Historic England

**NEW MILLS, BROUGHAM ROAD, MARSDEN, HUDDERSFIELD, HD7 6AZ
Application No. 2026/62/90232/W**

Thank you for your letter of 21 April 2026 regarding the above application for planning permission. On the basis of the information available to date, we offer the following advice to assist your authority in determining the application.

Drawing Title
BOUNDARY CONTEXTUAL ELEVATIONS - SHEET 3

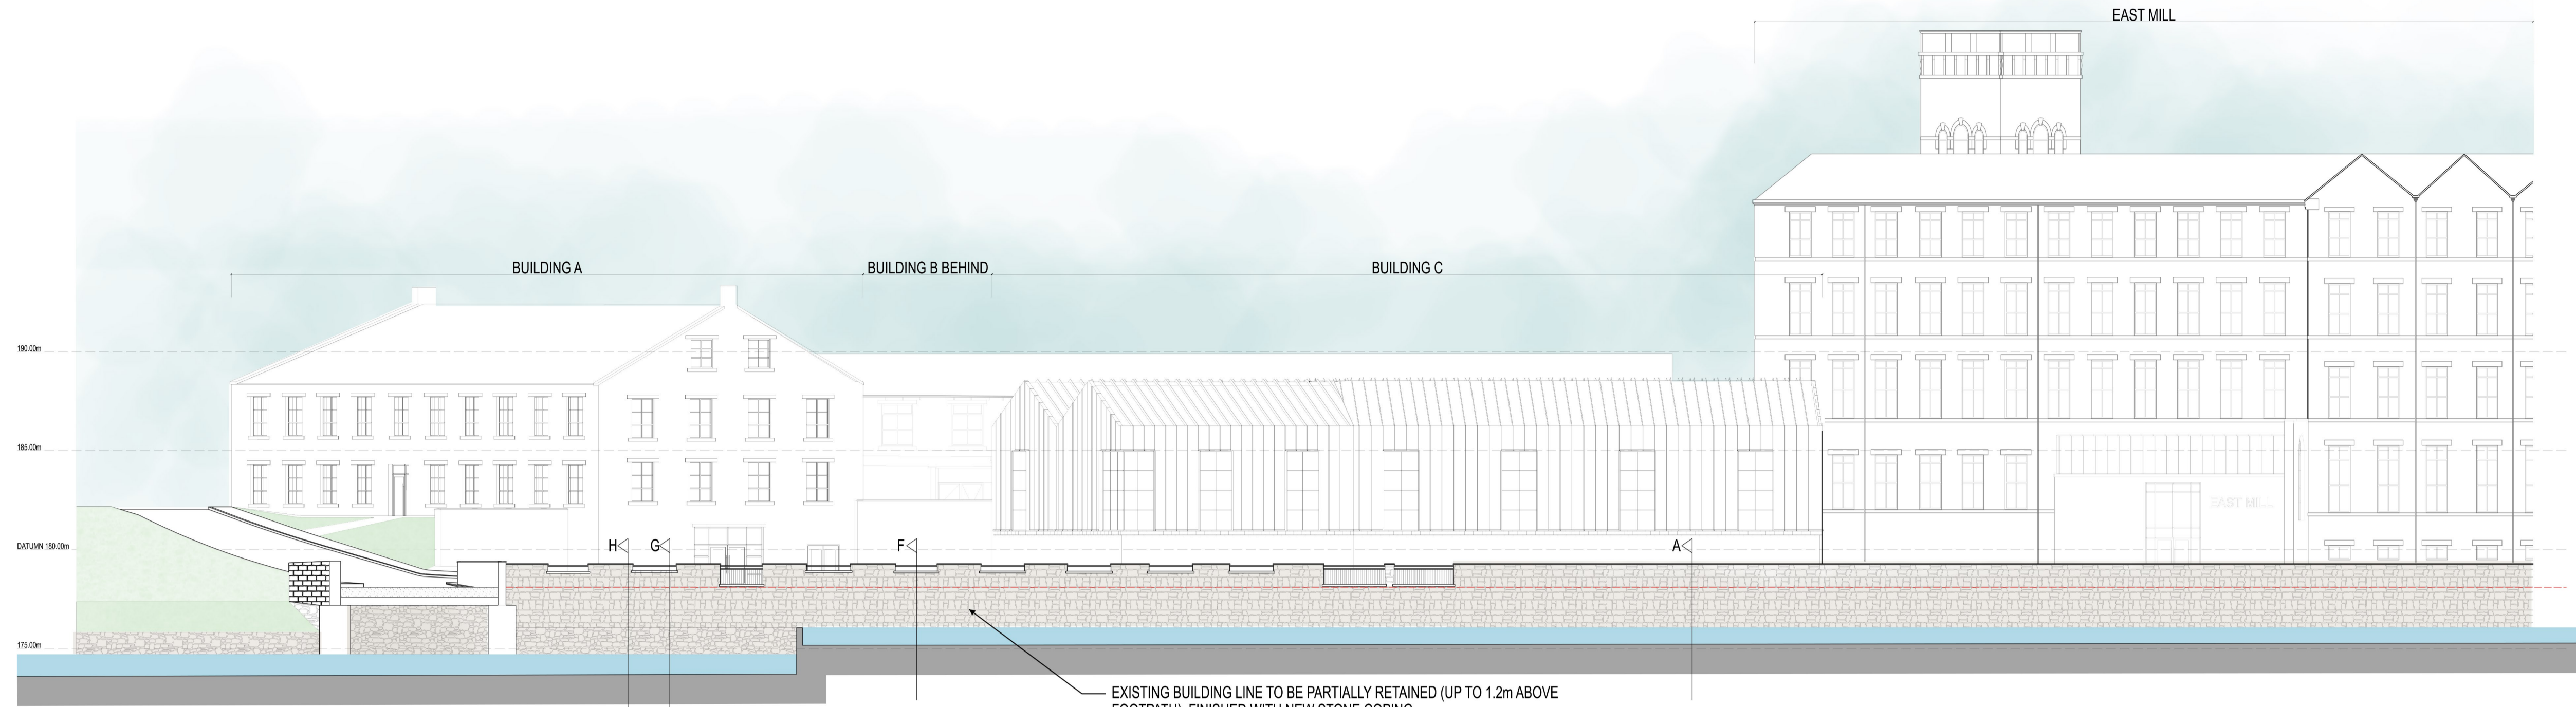
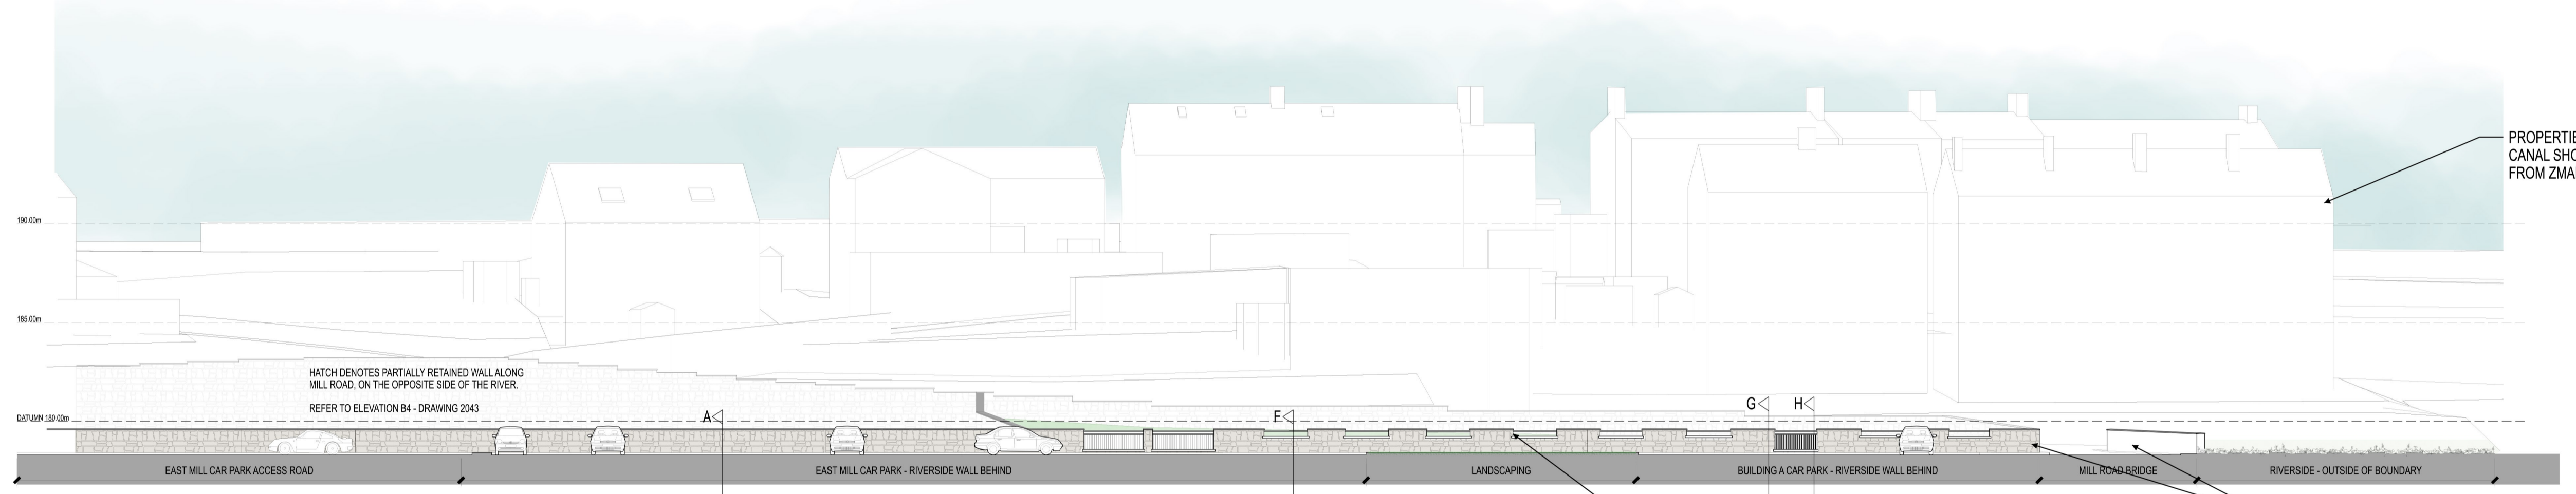
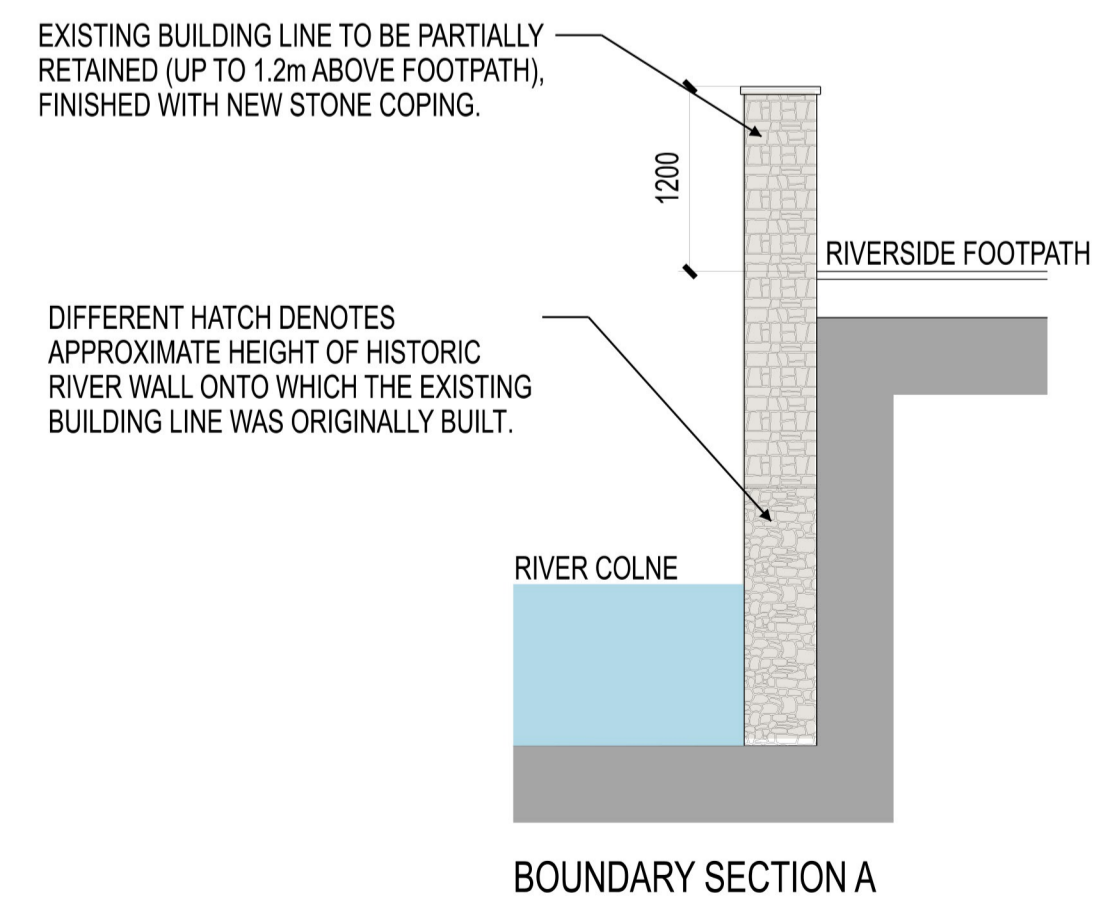
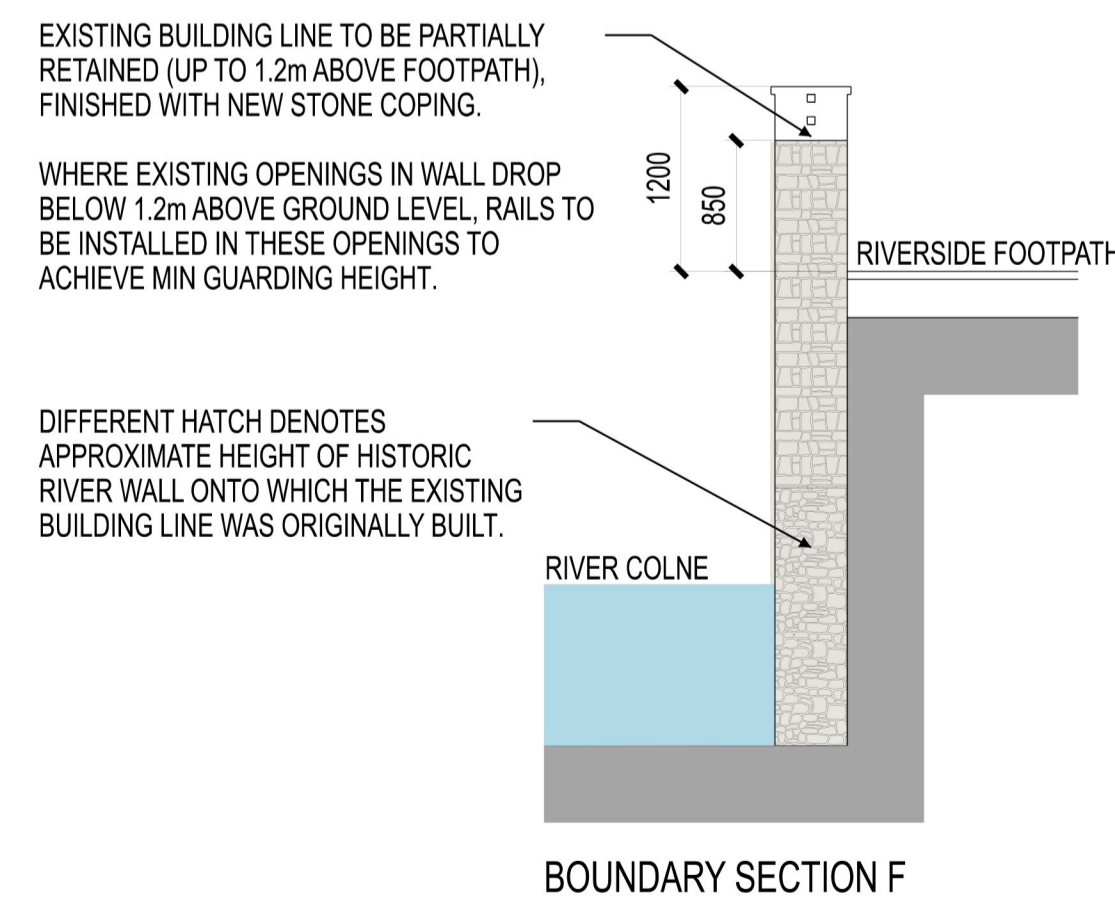
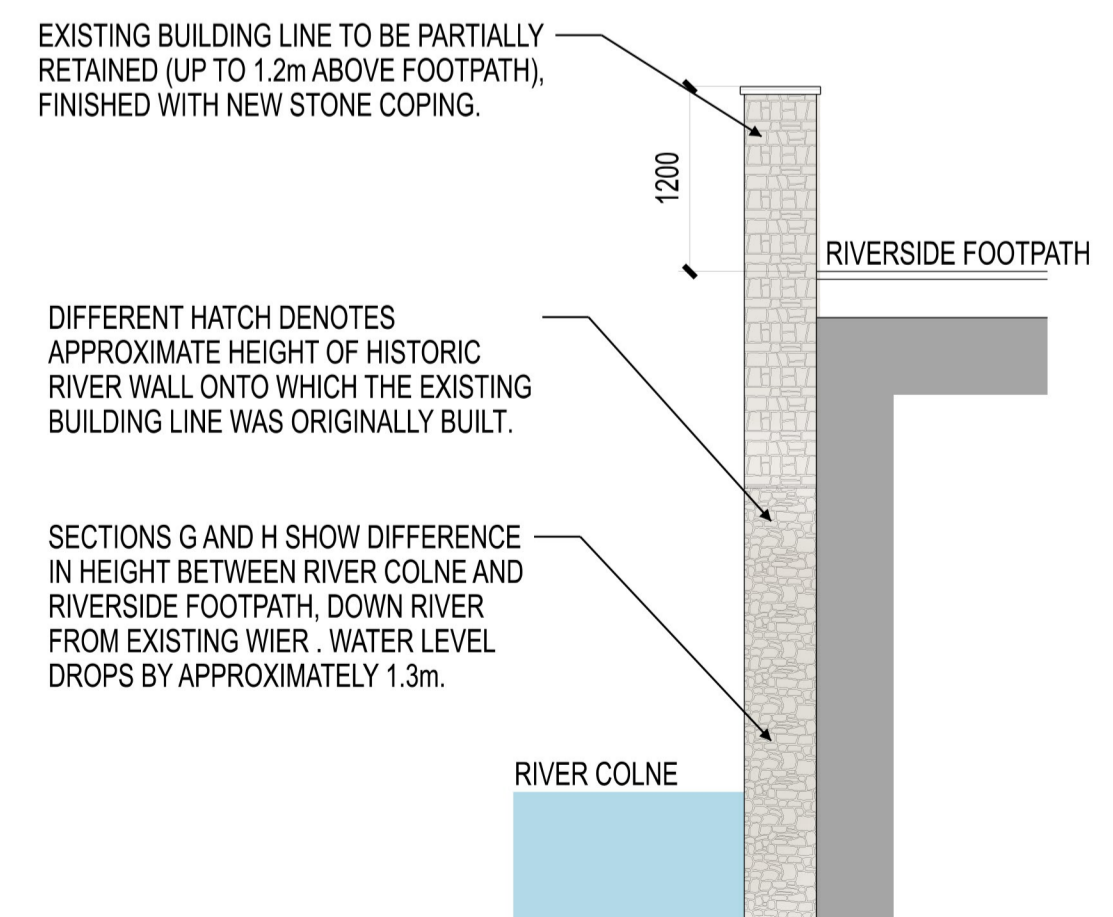
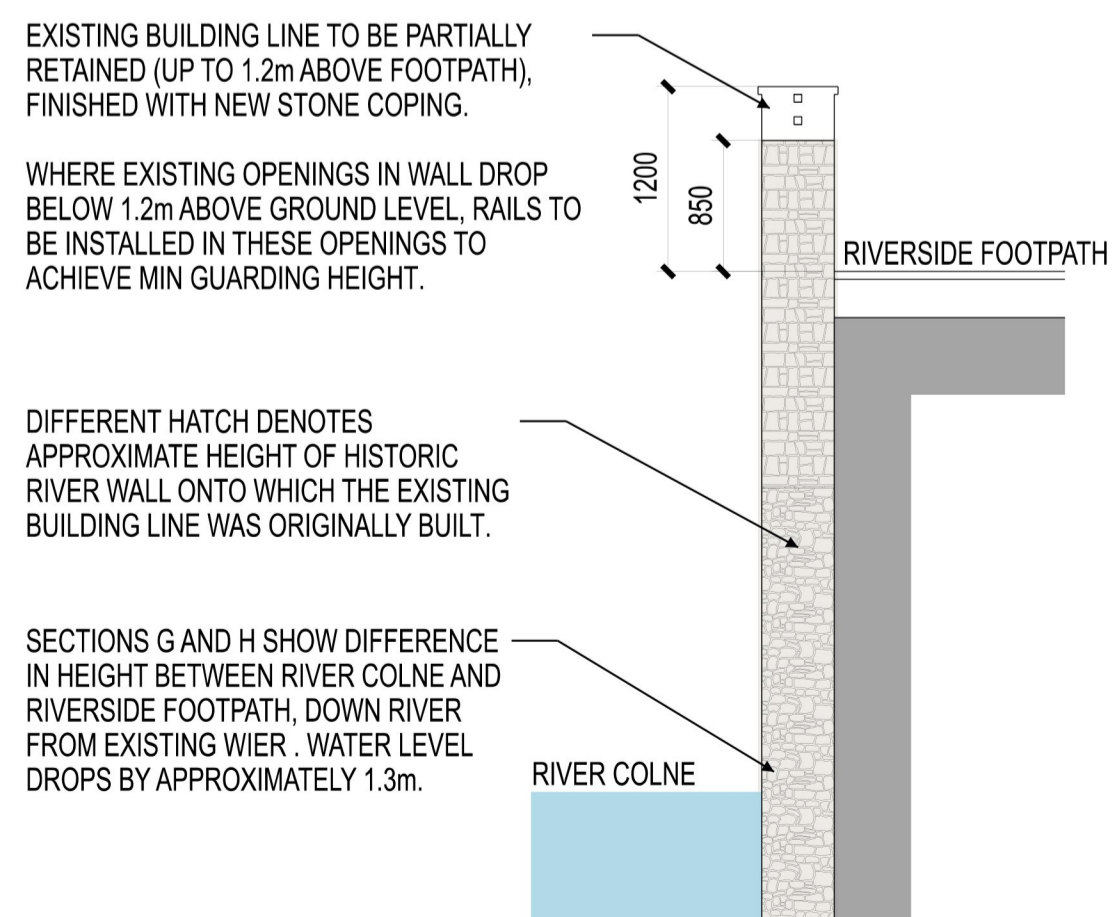
The proposals to remove the majority of the northlight and weaving sheds would cause a small amount of harm to the significance of the conservation area through diminished illustrative values and a small loss in the understanding of the mill complex.
